Ribble Valley Borough Council
Housing & Development Control

Your ref: 3/2023/0546
Our ref: D3.2023.0546
Date: 15th September 2023

Application no: **3/2023/0546**

Proposal: **Demolition of existing single-storey side and rear extensions, and construction of two-storey extension to the side and single-storey extension to the rear.**

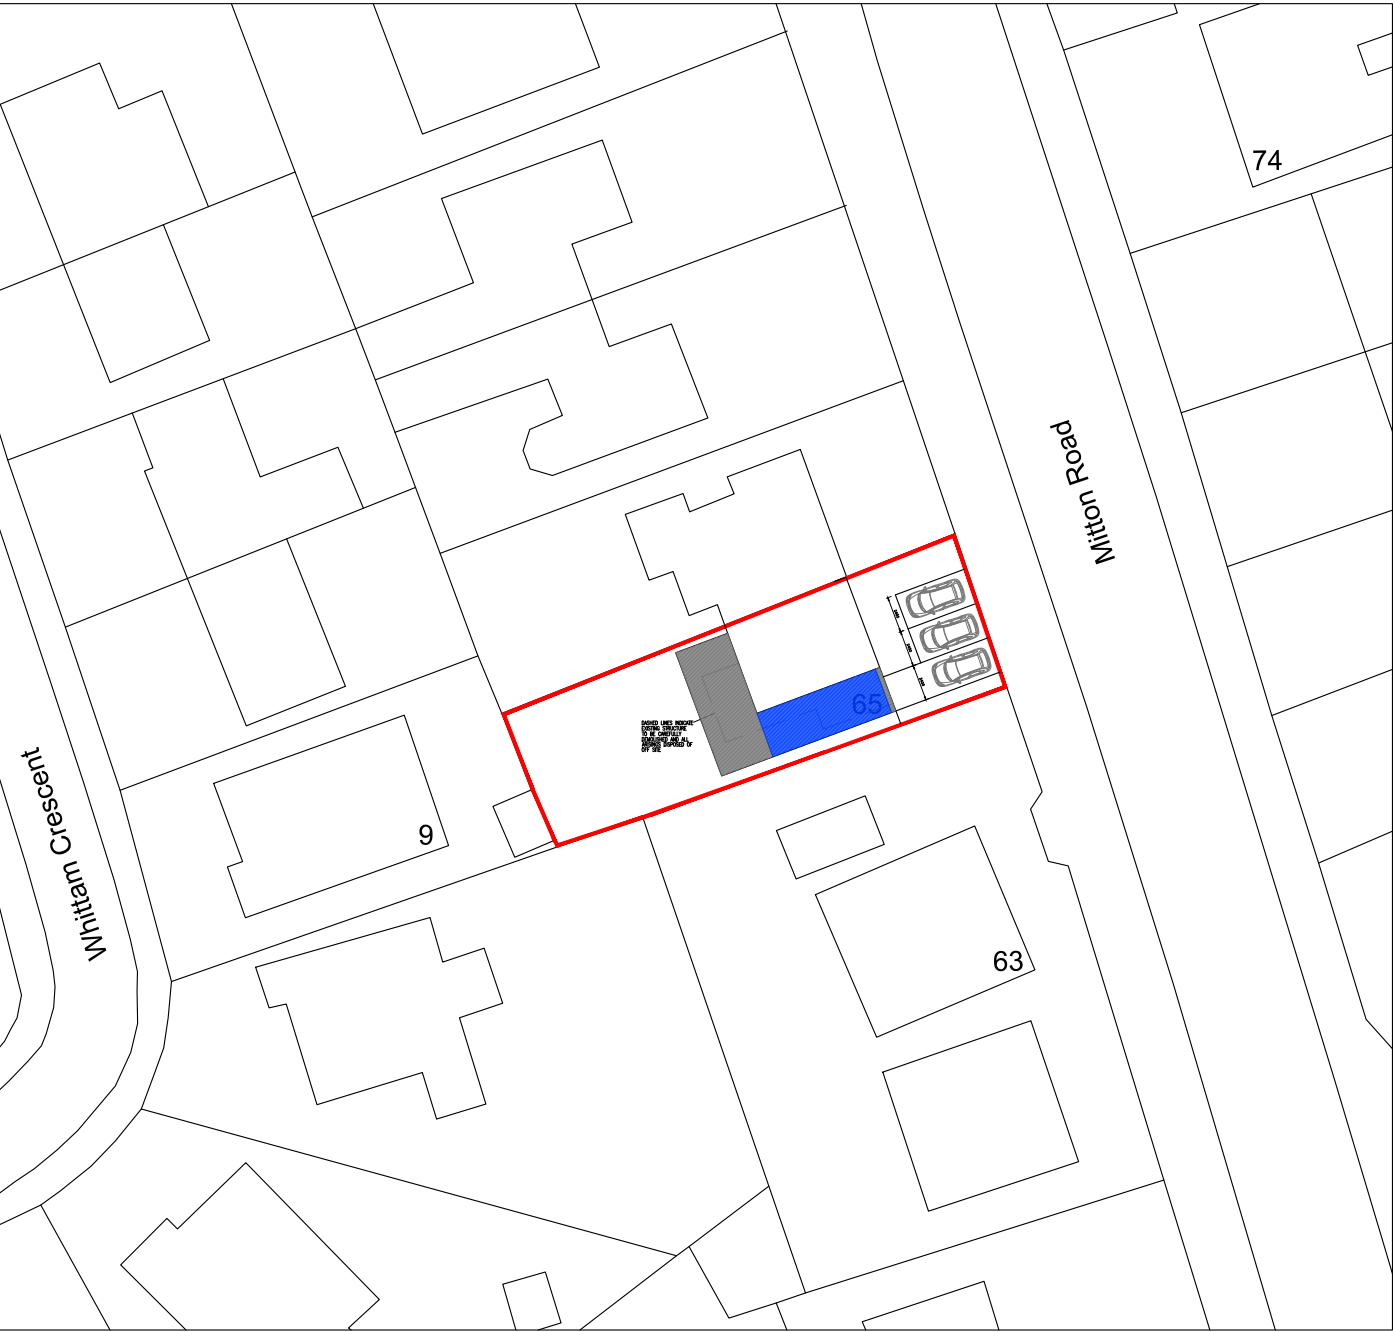
Since then, the Agent has submitted drawing number Wilson/04 Rev A titled "Proposed Block Plan" which will be reviewed below.

As a consequence of 3 car parking spaces being required, the Agent has provided drawing number Wilson/04 Rev A titled "Proposed Block Plan" which shows as part of the application, the access will be extended to ensure that 3 car parking spaces can be provided on the existing driveway.

Due to the gradient at the site, the LHA will request that the works to the site access are undertaken a Section 278 agreement with additional gullies likely to be required to prevent any surface water from entering the adopted highway.

2. No part of the development hereby permitted shall be occupied until such time as the access arrangements shown on drawing number Wilson/04 Rev A have been implemented in full.

parking and turning facilities have been implemented in accordance with drawing number Wilson/04 Rev A. Thereafter the onsite parking provision shall be so maintained in perpetuity.

Rev.	Description	By	Date
Project Mr. Discretion 65, Mitton Road Whalley, Clitheroe Lancashire BB7 9RY		Drawing Title Proposed Layouts Drawing No. Wilson/02	
		Rev. B	
Drawn by Scale P.E. 1:50@A1		Date May '23

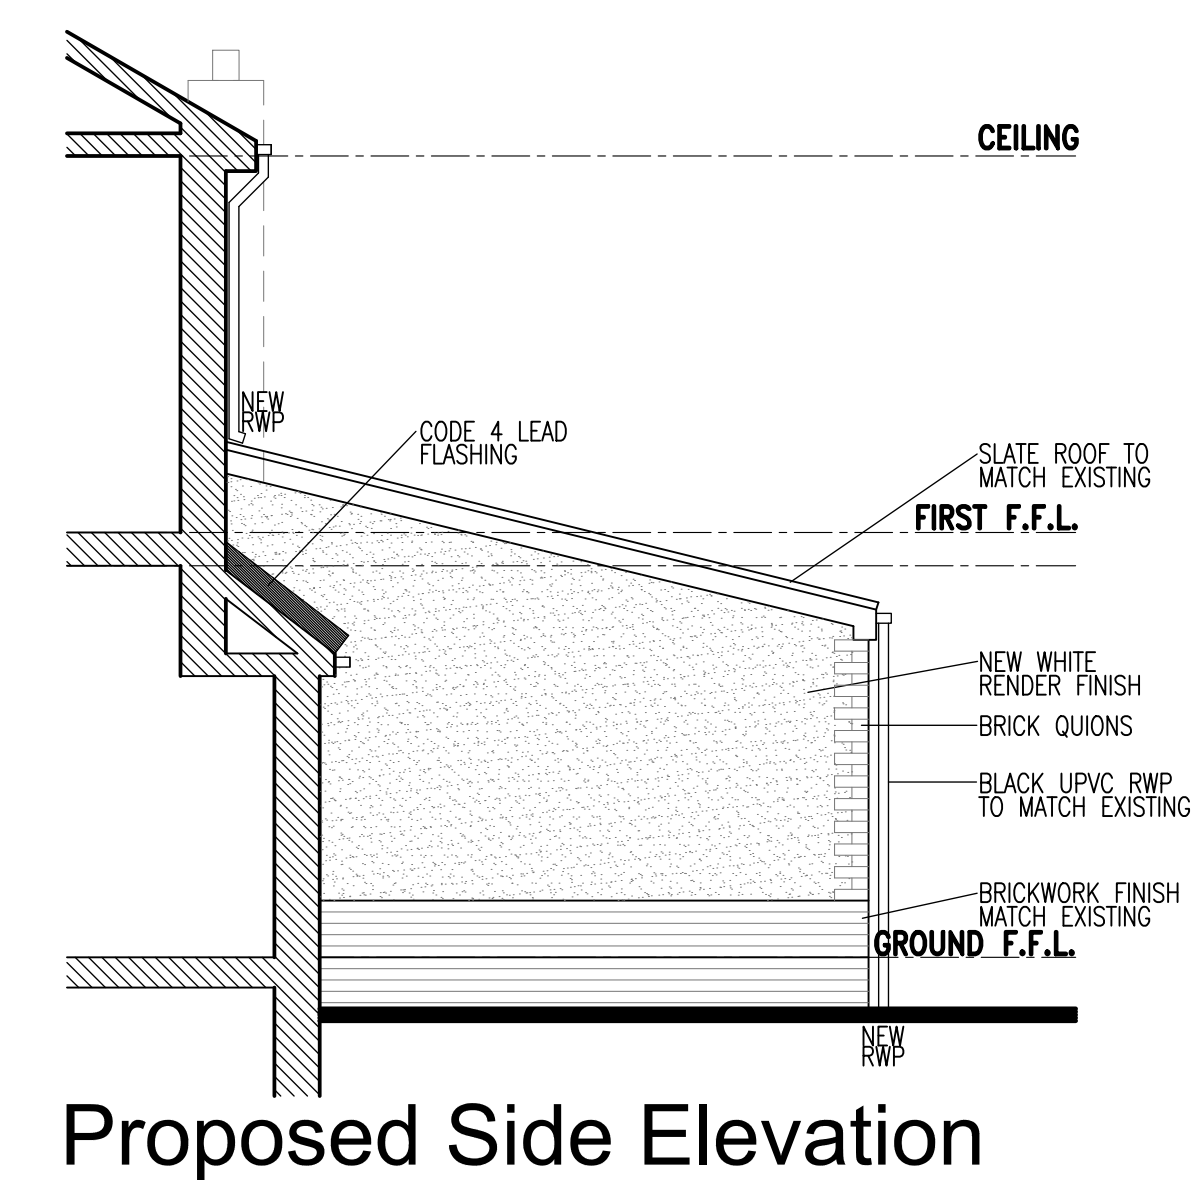
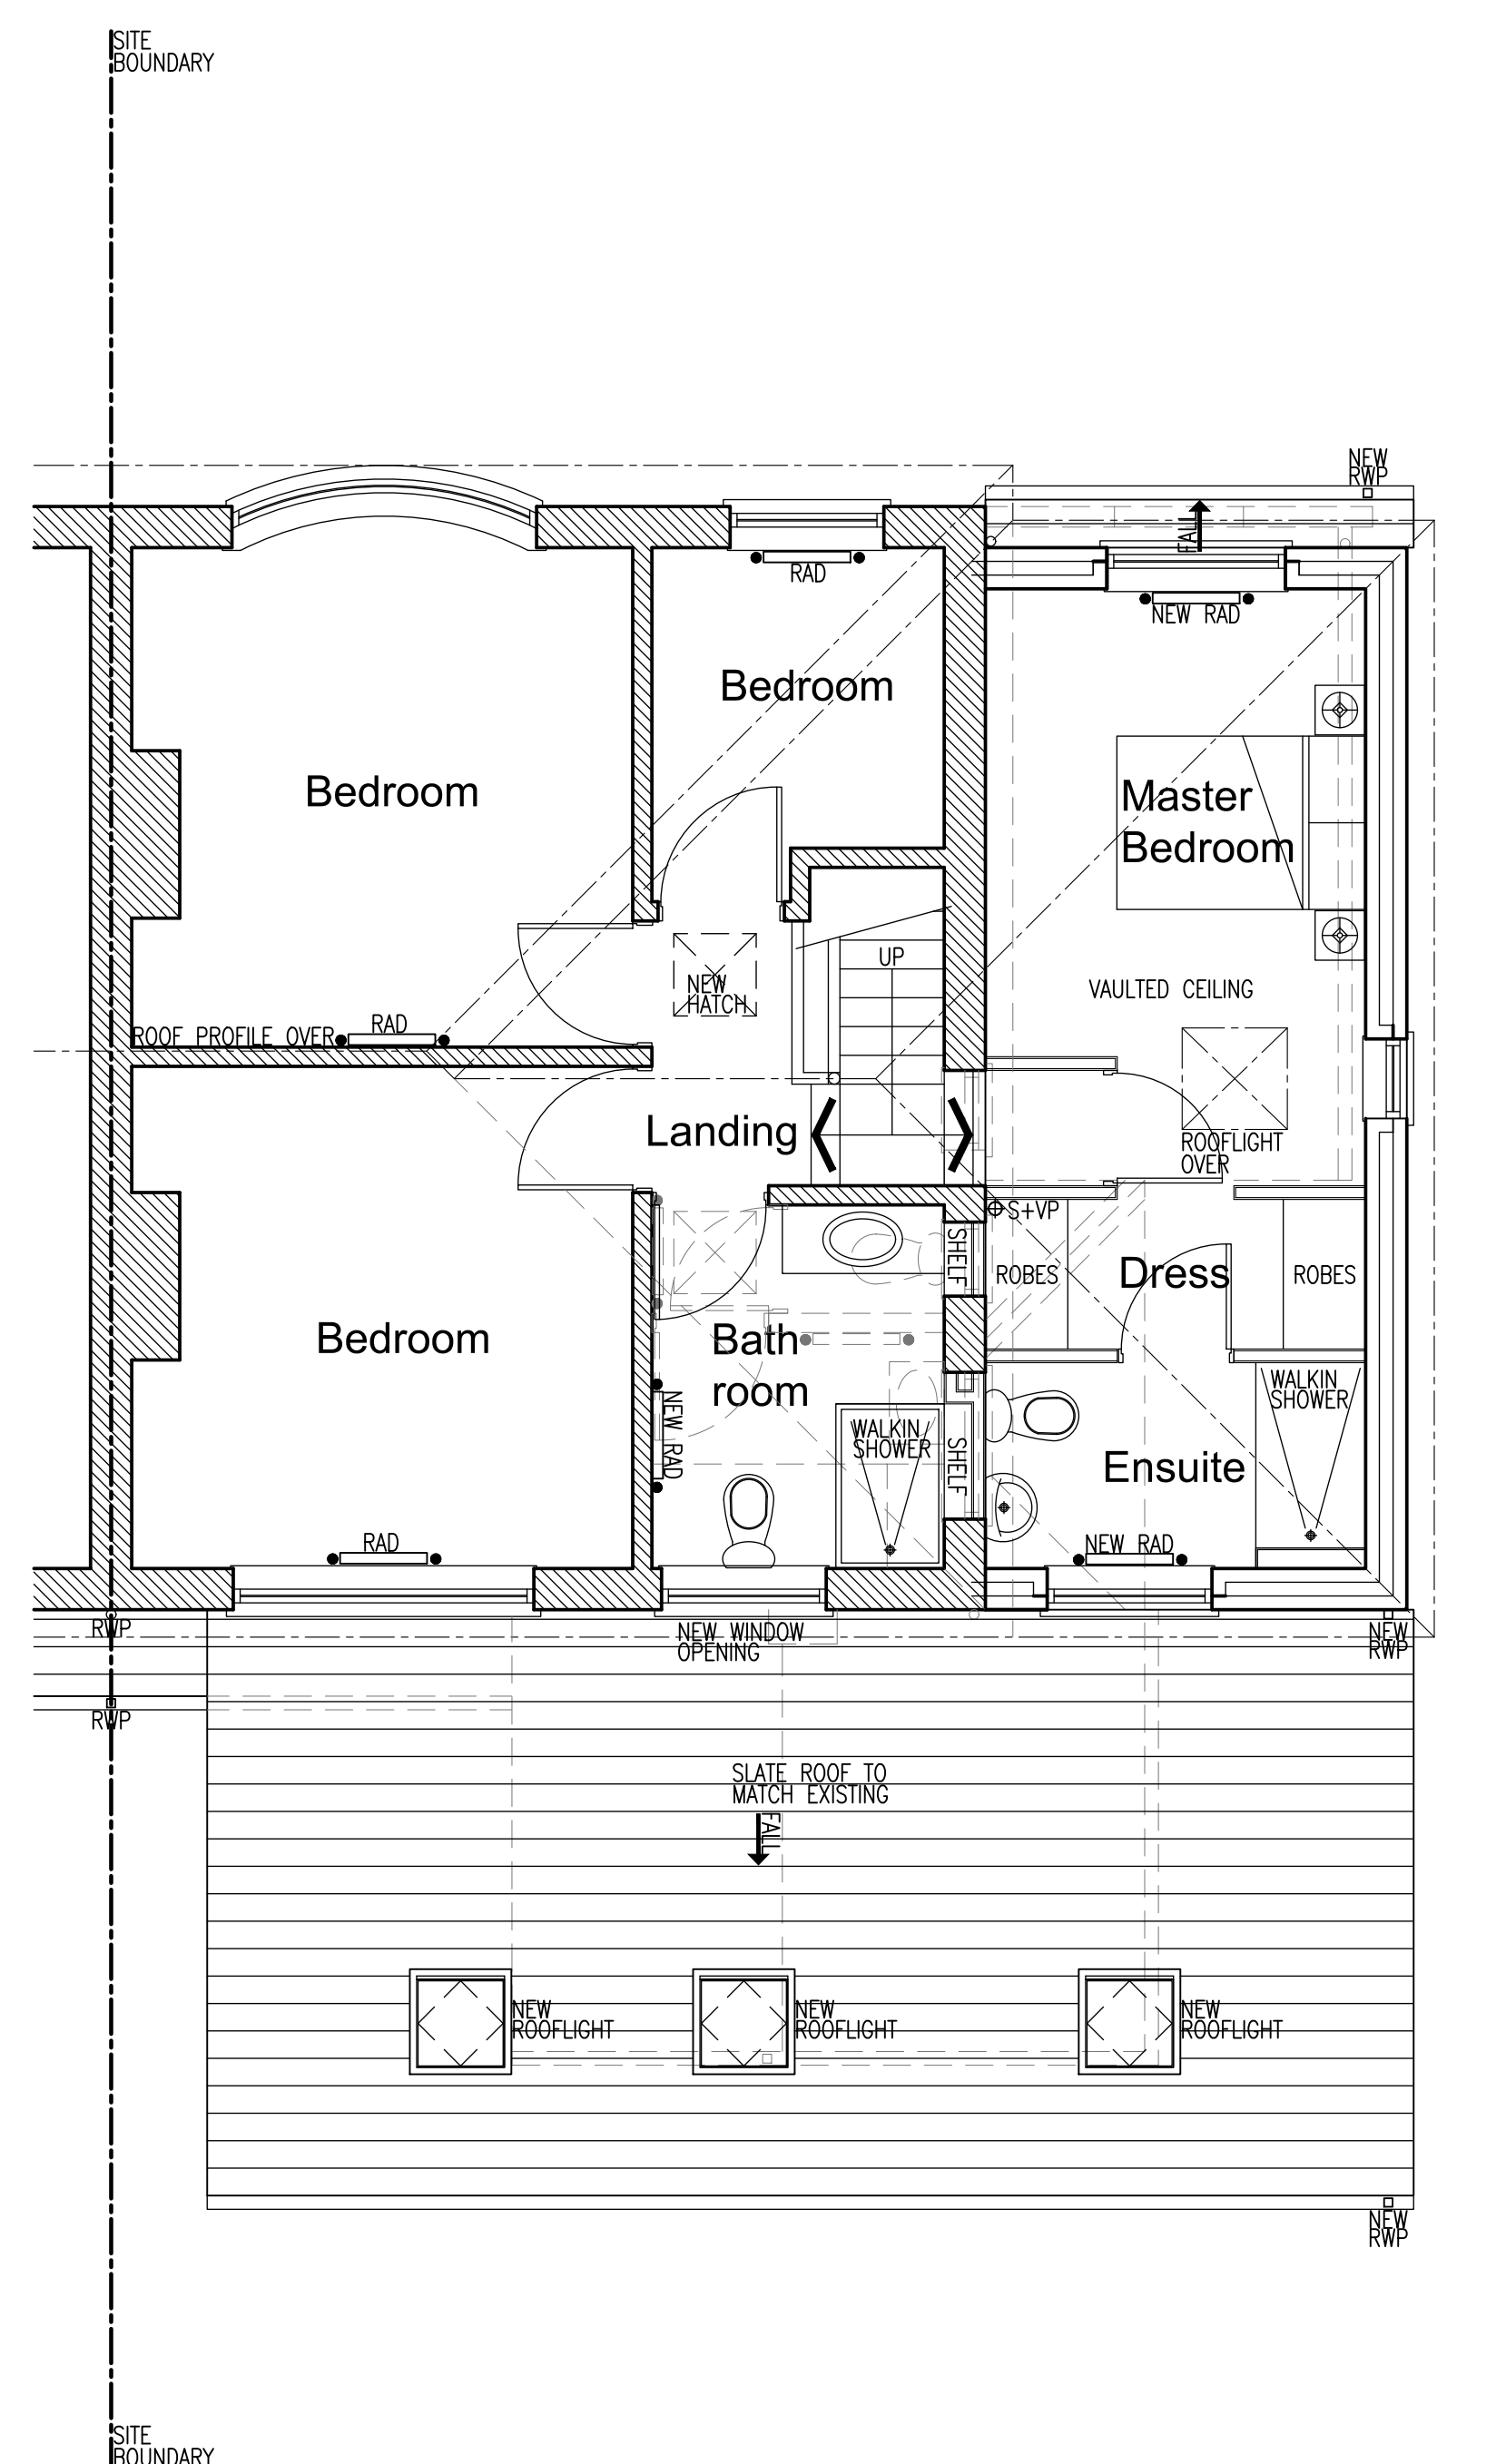
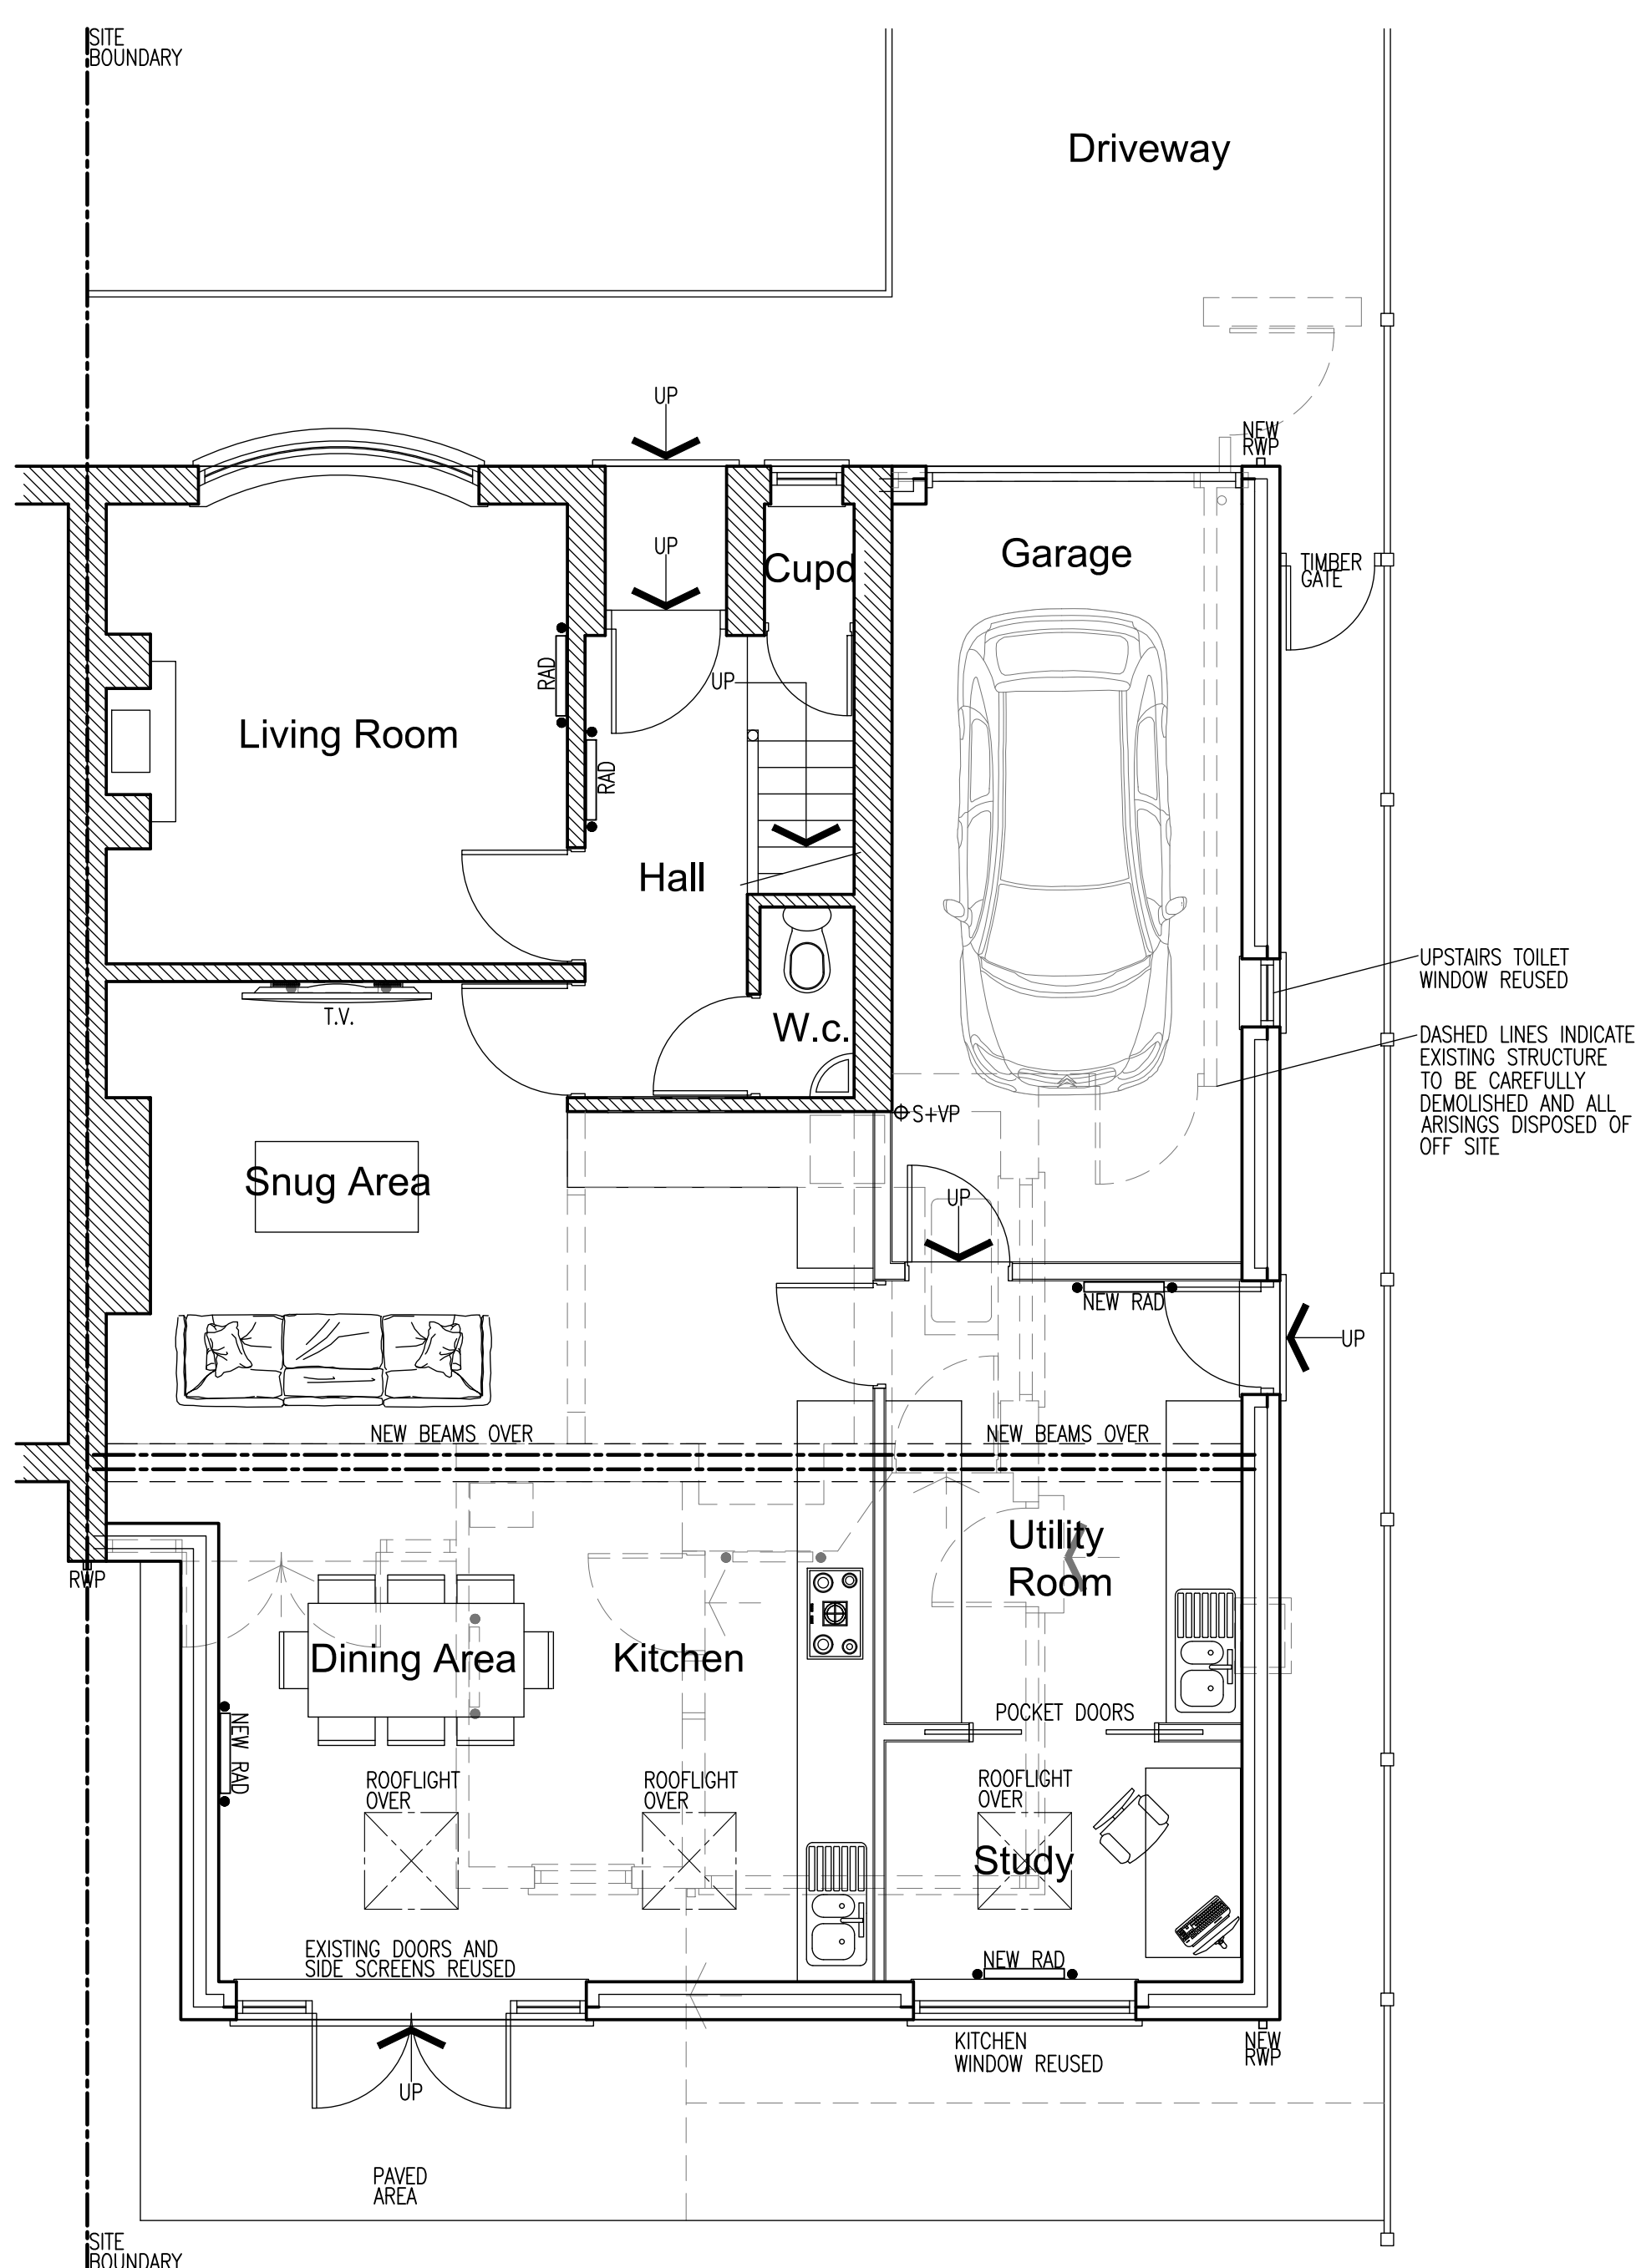
The LHA have reviewed drawing number Wilson/02 Rev A titled "Proposed Layouts" and are aware that the number of bedrooms at the dwelling will increase from 3 to 4. For the dwelling to comply with the LHAs parking guidance as defined in the Joint Lancashire Structure Plan, the LHA require the dwelling to provide 3 car parking spaces.
